Recommendation Report for Planning Permission for Works or Extension to a Dwelling

REF NO: M/92/18/HH

LOCATION: 2 Elmer Court
Elmer
Middleton- on- Sea
PO22 6JT

PROPOSAL: Replacement two storey rear extension, balcony & alterations (resubmission following M/62/17/HH).

West Elevation

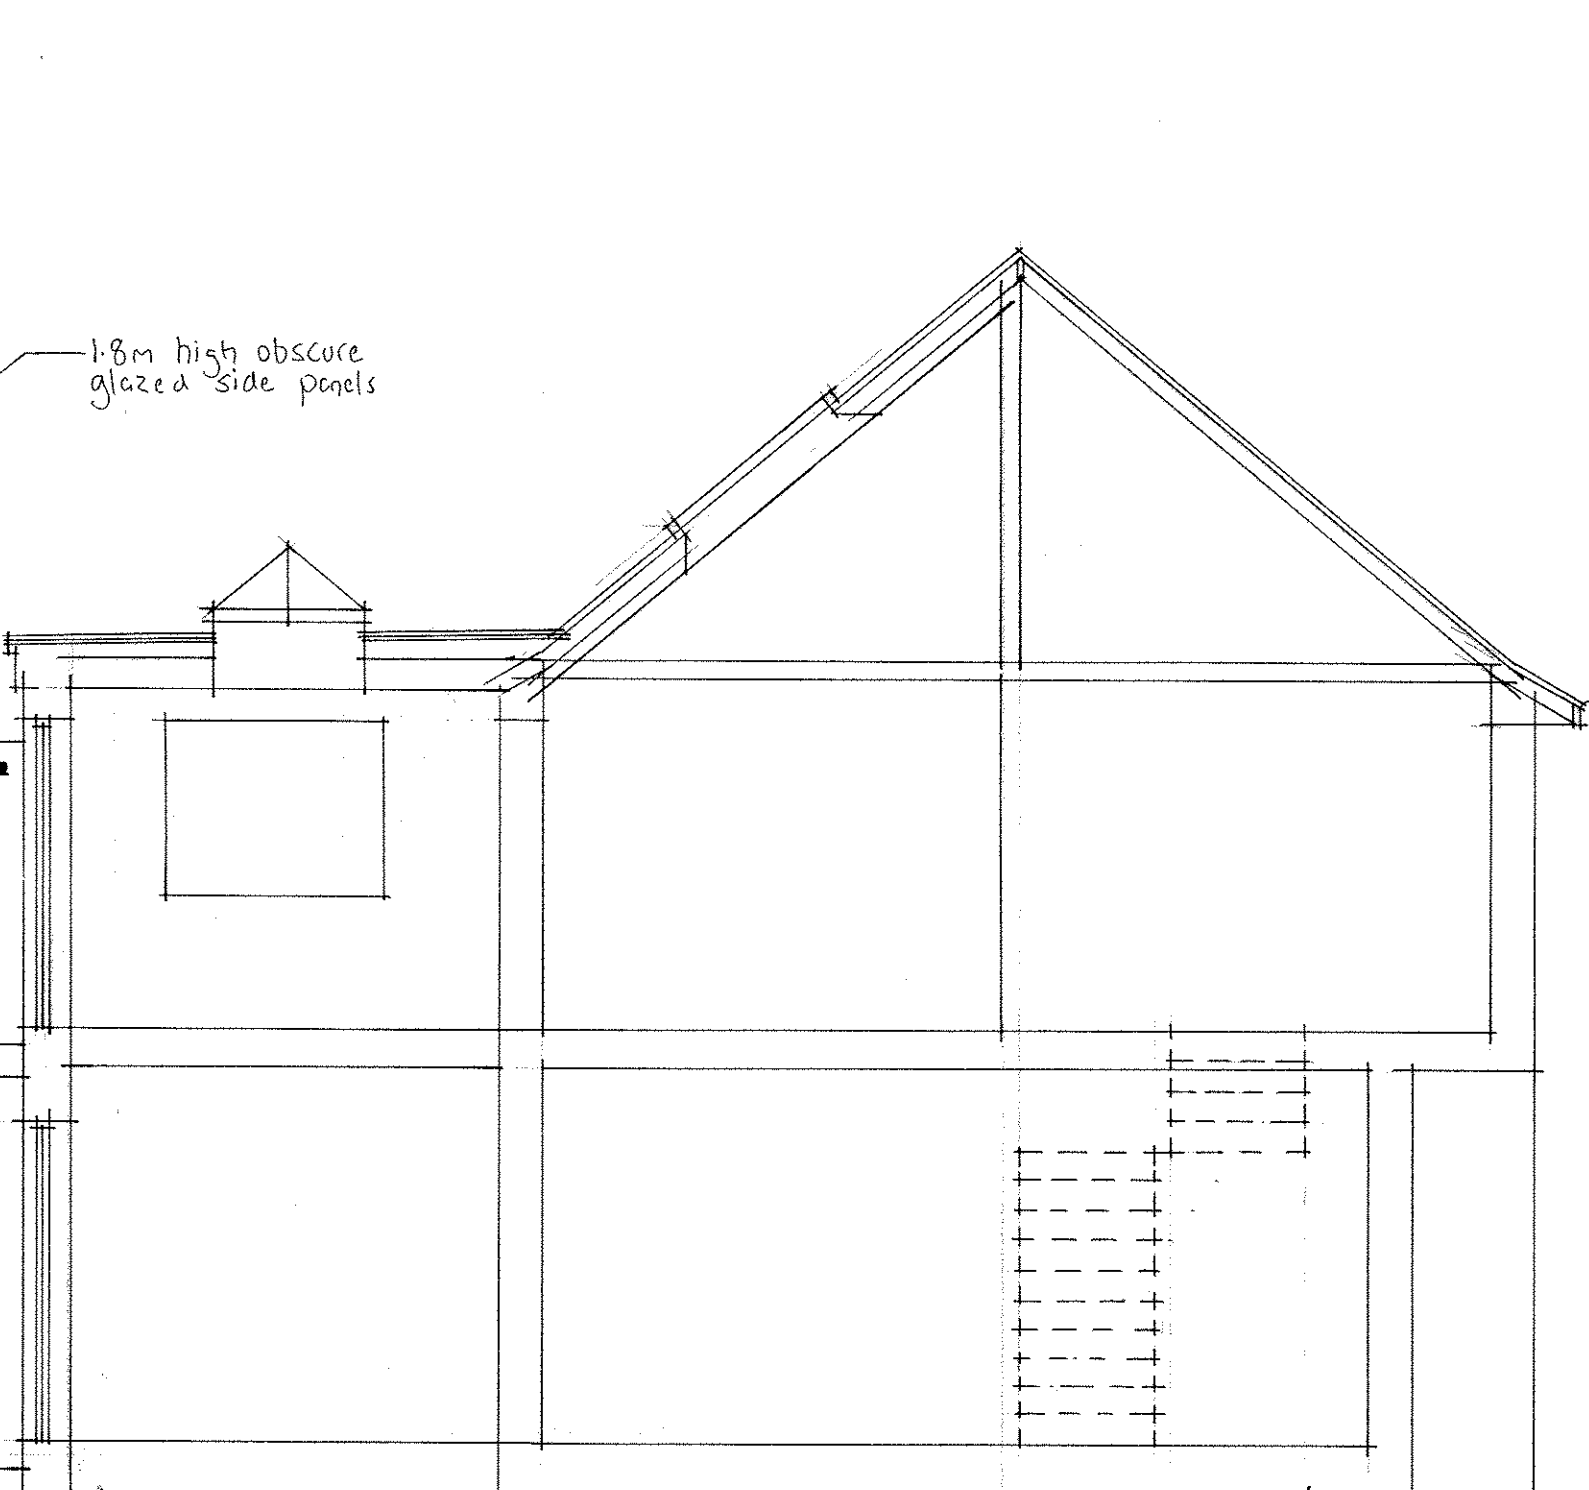
- The footprint of the proposal is slightly larger than the footprint of the existing extension.
- The Westernmost window on the proposed extension is considered to cause an unacceptable loss of privacy to the occupiers of #1 Elmer Court. The objector suggests that this window should be conditioned to be obscure glazed as to prevent available views.
- This window will also cause light pollution issues due to its separation distance from the same window.

The proposed two storey extension will replace an existing extension in this location. This existing extension features significant obscure glazing on the Southern, Eastern and Western elevations, and therefore gives rise to overlooking to the gardens to the East and West. However, the proposal is considered to cause an unacceptable loss of privacy to the occupants of #1 Elmer Court, by way of providing views into a principle room in the South East of the dwelling. It will be conditioned that this window will be obscure glazed below 1.7m in order to prevent this unacceptable loss of privacy.

Reason: In the interests of amenity in accordance with policies D DM1 and D DM4 of the Arun Local Plan.
- 4 The first floor window on the west elevation of the building shall at all times be glazed with obscured glass fixed to be permanently non-opening. The obscure glazed and permanently fixed shut window will be installed within 1 month of completion of the works and shall be retained as such in perpetuity.

First Floor Plan

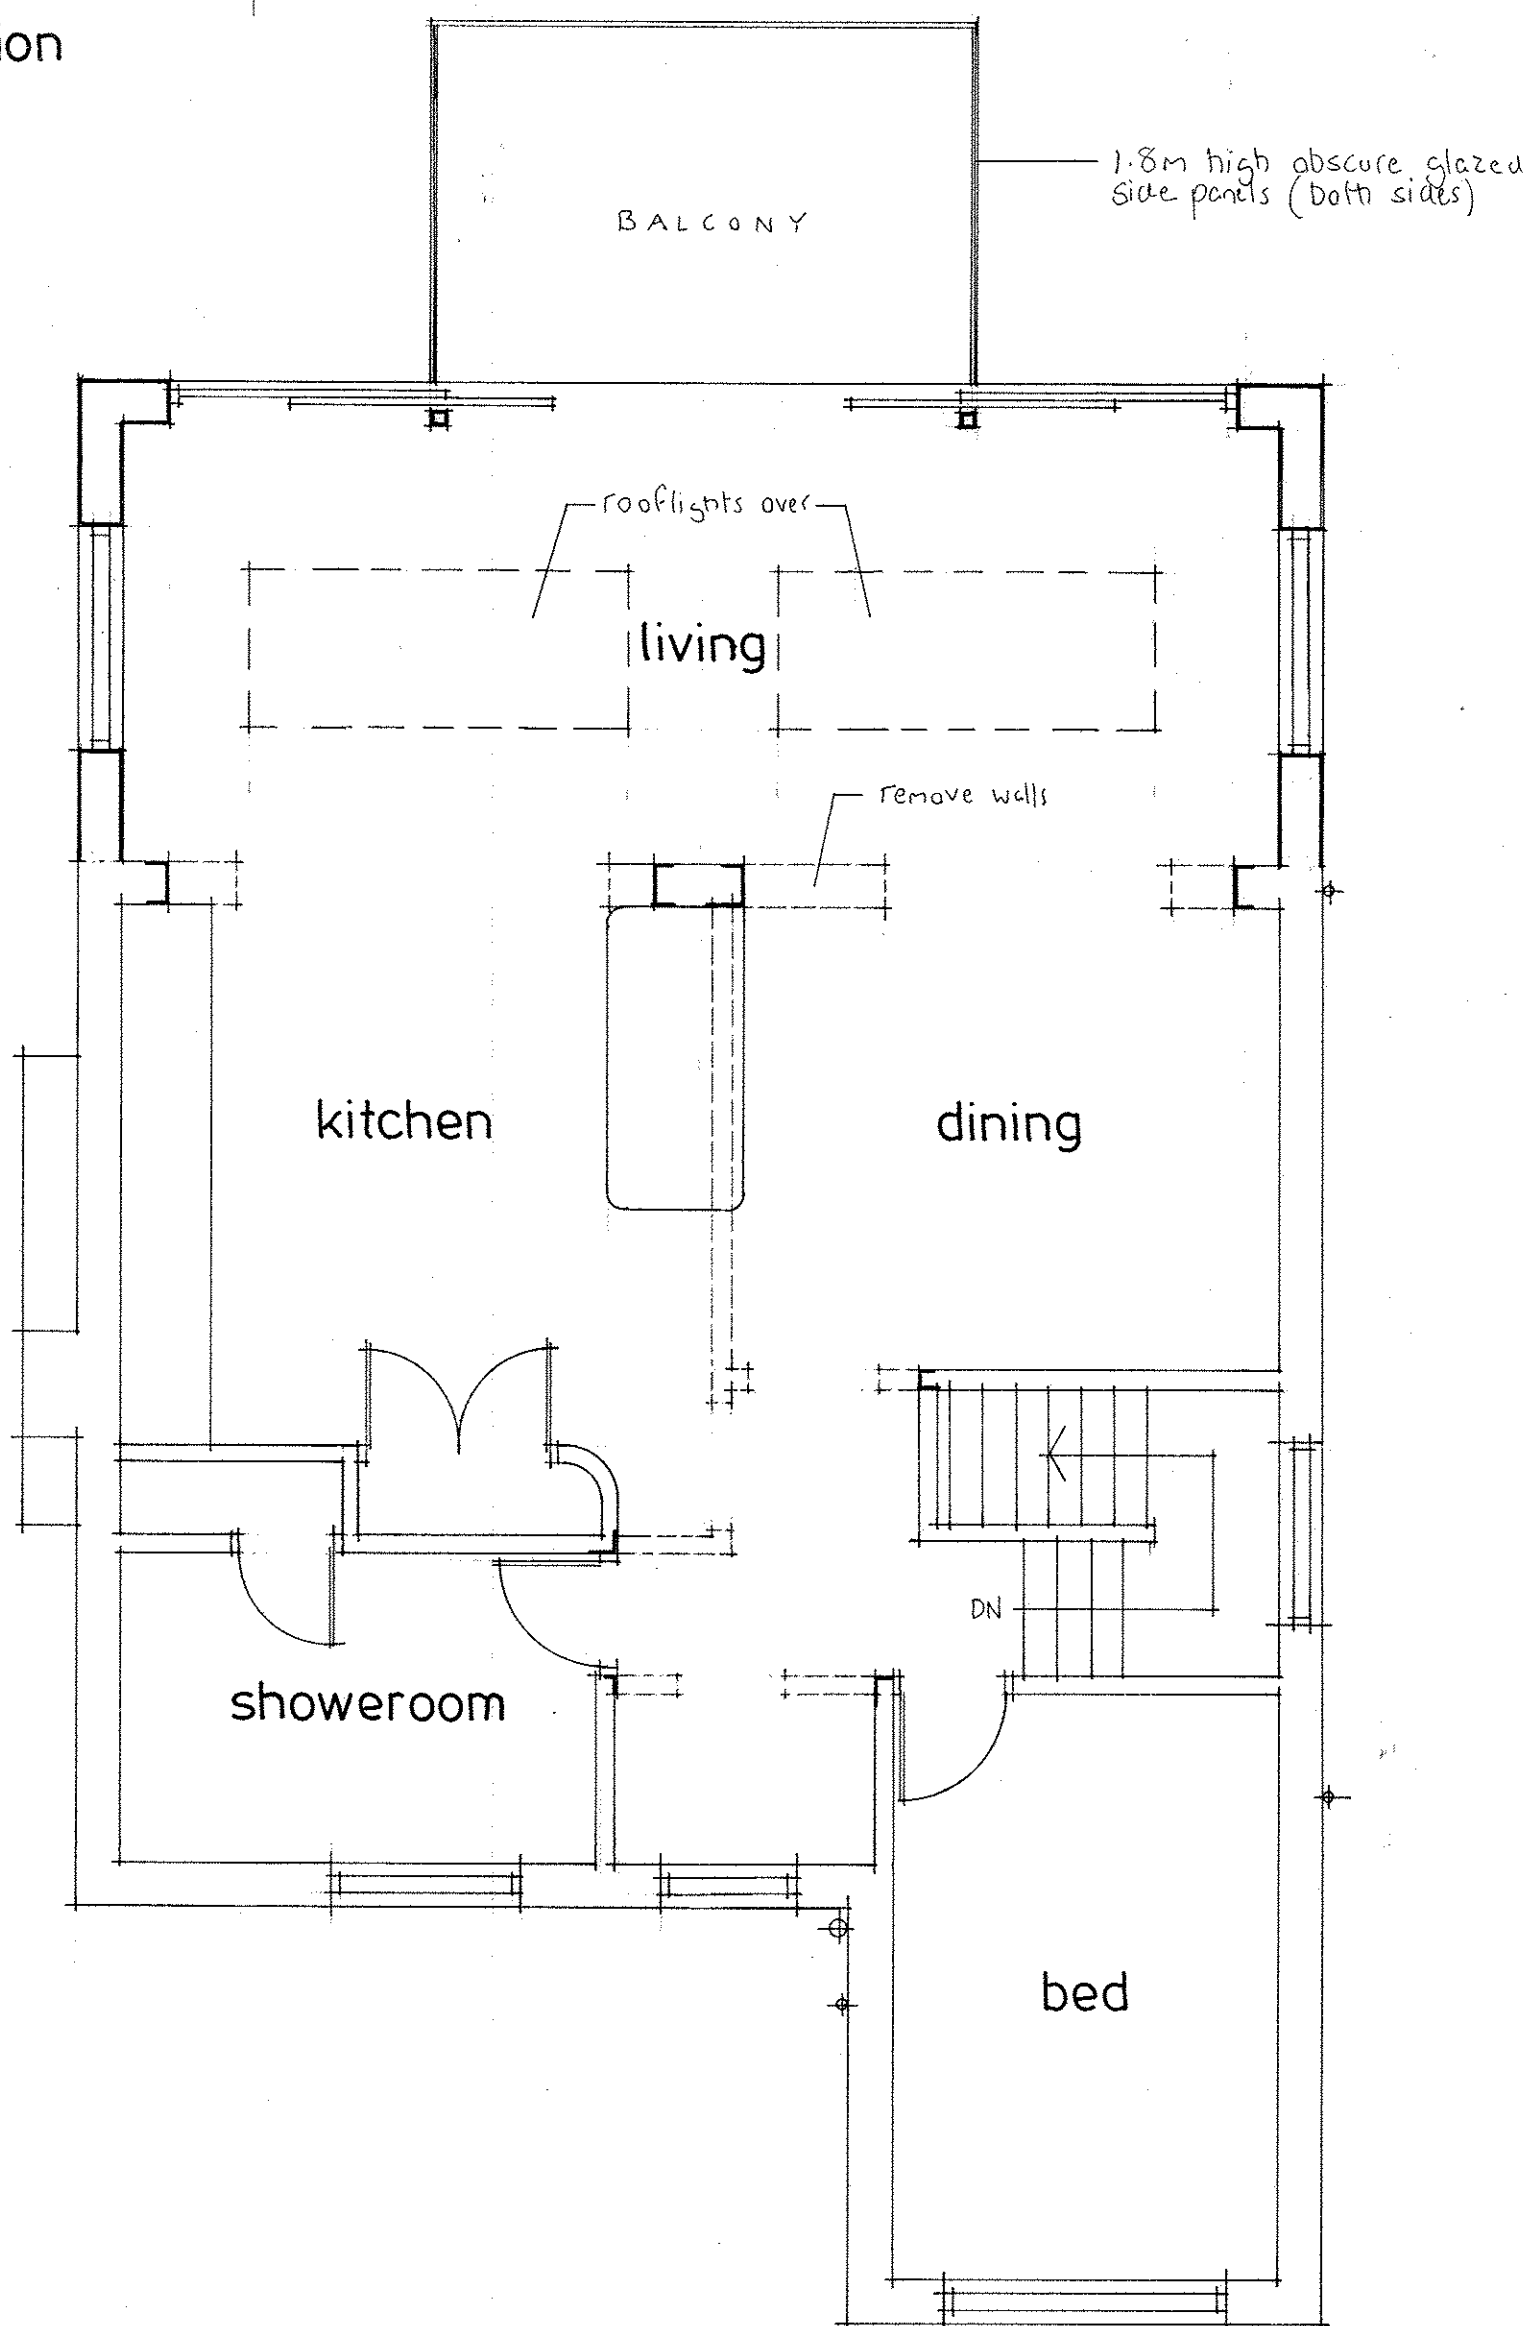
The proposed balcony will be situated approximately 3m from the Eastern and Western boundaries of the application site. It is considered that the proposed balcony has the potential to give rise to unacceptably adverse overlooking of neighbours and as such a condition has been included with this recommendation report requiring details of 1.8m high obscured screening on the eastern and western edges of the balcony. The proposed screening by virtue of its distance from the boundary is not considered to give rise to any unacceptably adverse overbearing or overshadowing impacts.

Reason: To protect the amenities and privacy of the adjoining property in accordance with policies D DM1 and D DM4 of the Arun Local Plan.
- 5 The balcony hereby approved shall not be installed until full details of 1.8m high obscured screening to the eastern and western edges of the balcony have been submitted to and approved by the Local Planning Authority. The obscured screening hereby approved shall be installed within 1 month of completion of the works and shall be retained in perpetuity.
